From: Iqraa Malik
Sent: 20 July 2020 11:14
To: Sian Eggington
Subject: FW: Request for further information AW/161/20/HH
Attachments: 03-Proposed Plans.pdf; We sent you safe versions of your files

From: Ivon Blumer
Sent: 20 July 2020
To: Iqraa Malik
Subject: Re: Request for further information AW/161/20/HH

IVON BLUMER ARCHITECTS LTD			
PROJECT	Wakefield Way	DATE	06/07/19
TITLE	Proposed Plans	DRG NO	IBA/520/03
SCALE	1 : 100	REVISIONS

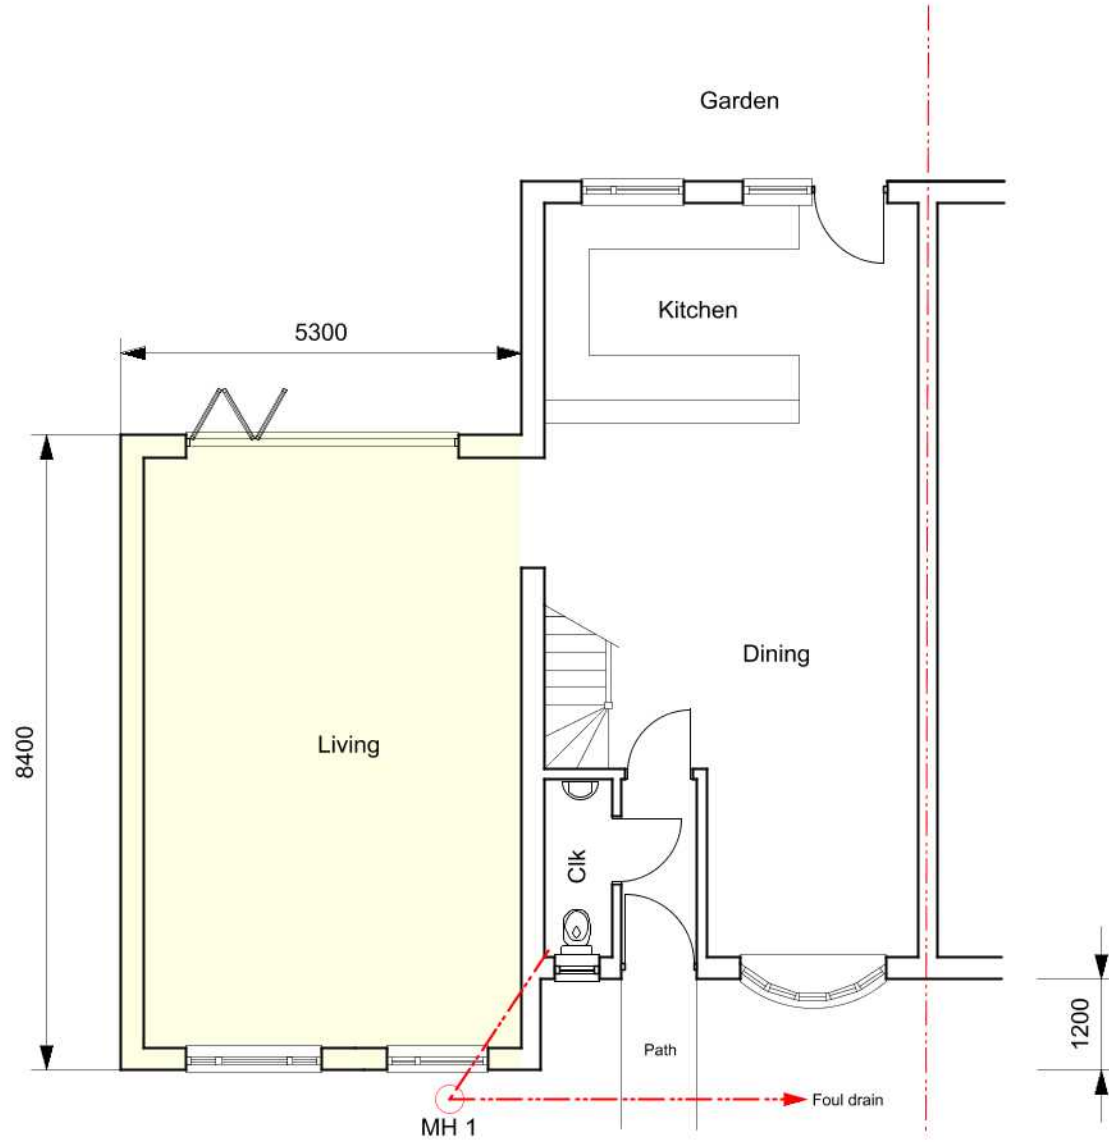
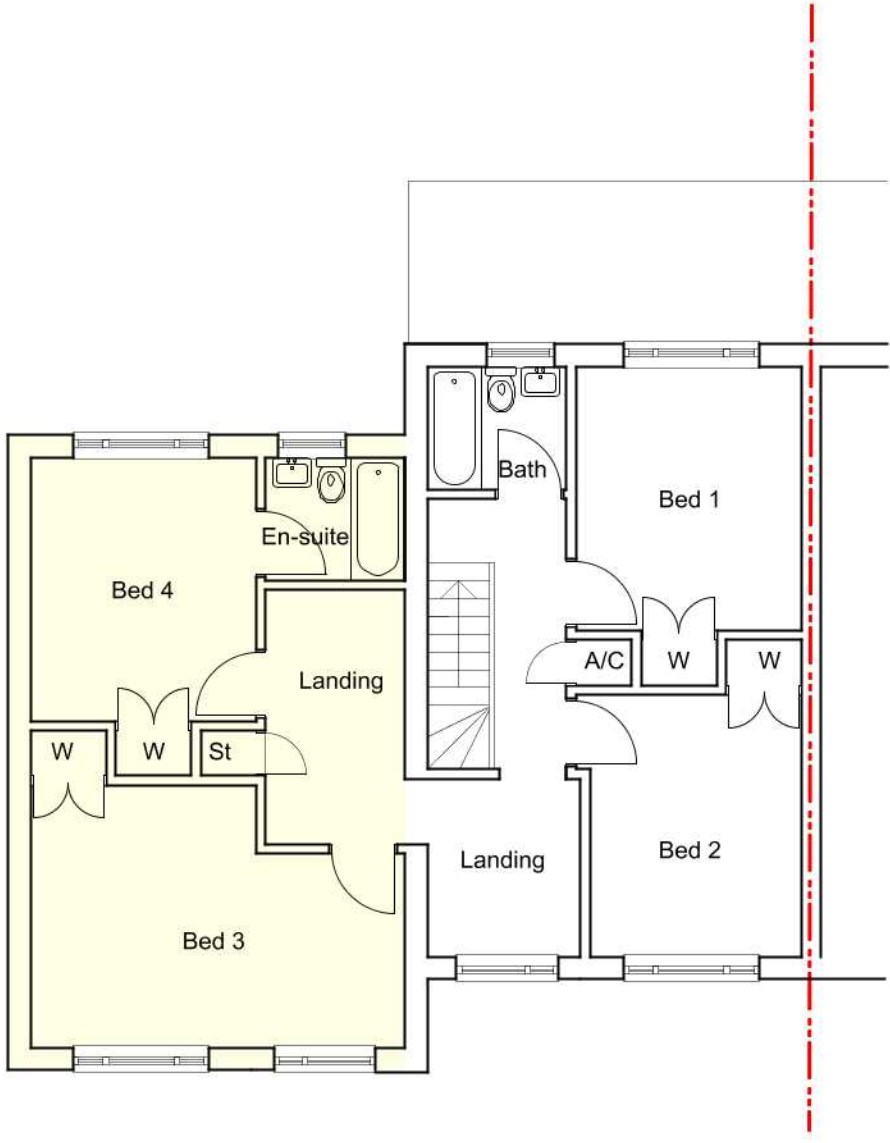
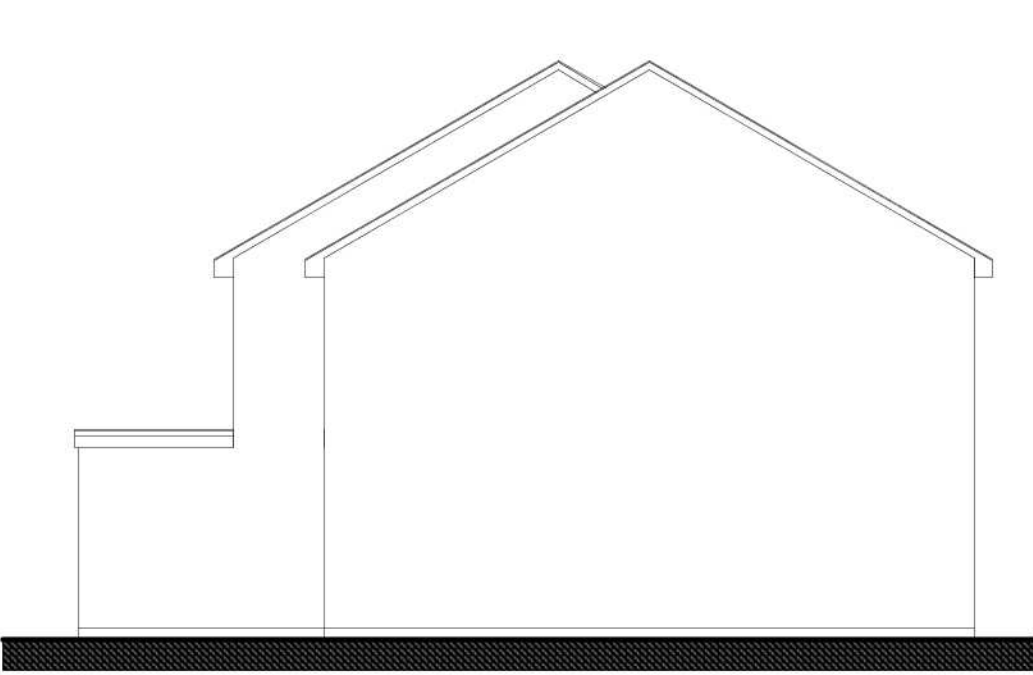
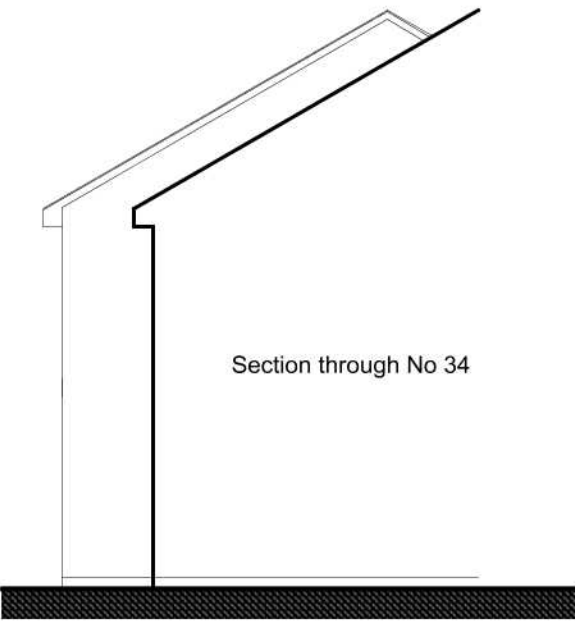
Unfortunately, the building line on the side elevation appears to be inconsistent with the ground floor plan. Please amend or with your permission we are able to amend this for you.

Try this, otherwise I don't know what you mean, happy for you to amend.

Requested information attached.
